WELWYN HATFIELD COUNCIL – DEVELOPMENT CONTROL
DELEGATED REPORT

APPLICATION No:	S6/2009/1178/LU
------------------------	------------------------

The erection of an outbuilding to the rear of the site. The proposed outbuilding would measure 11.2m in width by 4.3m in depth with a pitched roof to a maximum height of 4m. The proposed roof would have 4 slopes and a ridge length of 7m. The proposed eaves height would has been dimensioned to be 2.4m at the top of the gutter.

Project:	Gym Building		
Subject:	Proposed Elevations		
Client:	69 NORTHAW ROAD EAST CUFFLEY, HERTS EN6 4LY		
Drawing No:	ELA/6	Rev:	00
A3 Scale:	1:50	Drawn By:	CE
		Job No:	0015
		Date:	28/05/09

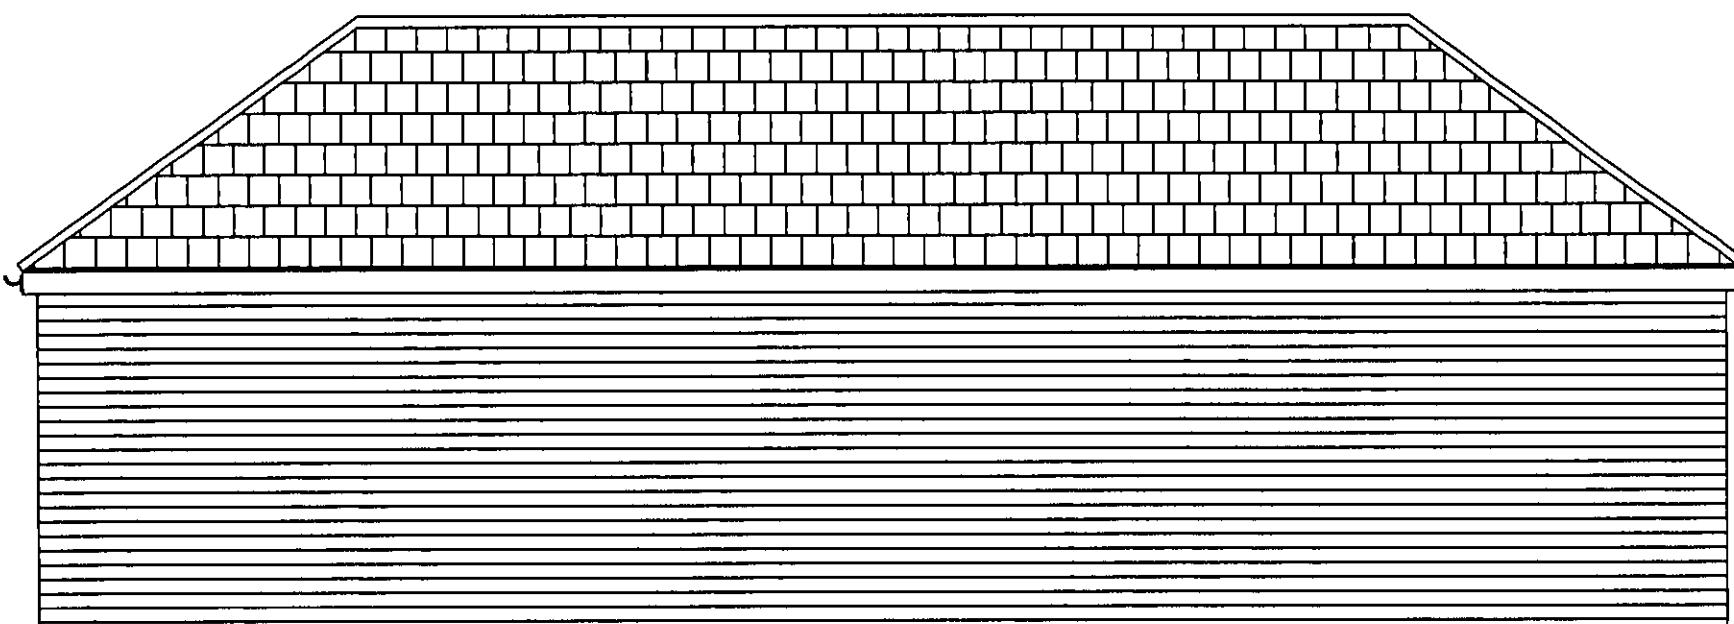
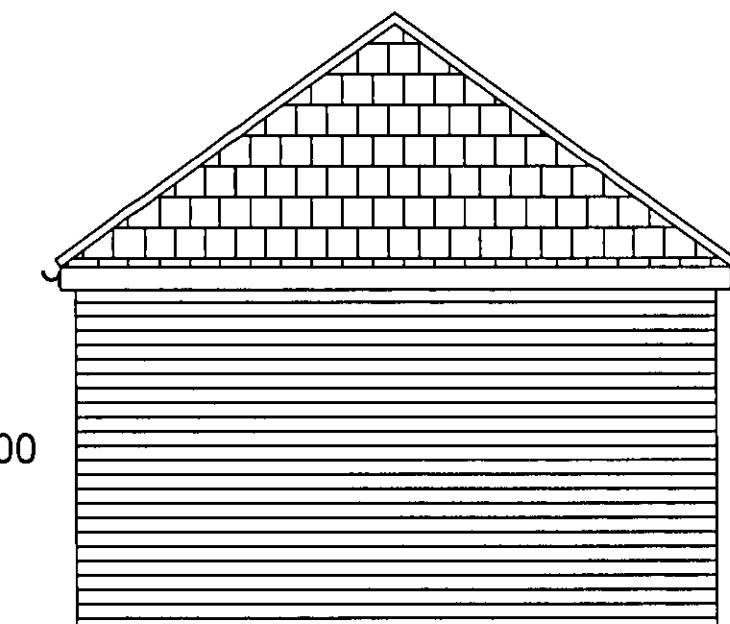
The proposed outbuilding would be sited close to the boundaries of the dwellings plot and have a maximum height of 4m. Due to the proposal being approximately 0.5m from the northern flank boundary and 0.4m from the southern flank boundary and eastern rear boundary, the proposal would not meet this requirement.

The proposed outbuilding would be sited within 2m of the rear and side boundaries of the dwellings curtilage and would have a roof exceeding 2.5m in height. Therefore, the proposed outbuilding does not comply with the provisions of Schedule 2, Part 1, Class E of the Town and Country Planning (General Permitted Development) Order 1995, as amended by the Town and Country Planning (General Permitted Development) (Amendment) (No.2) (England) Order 2008.
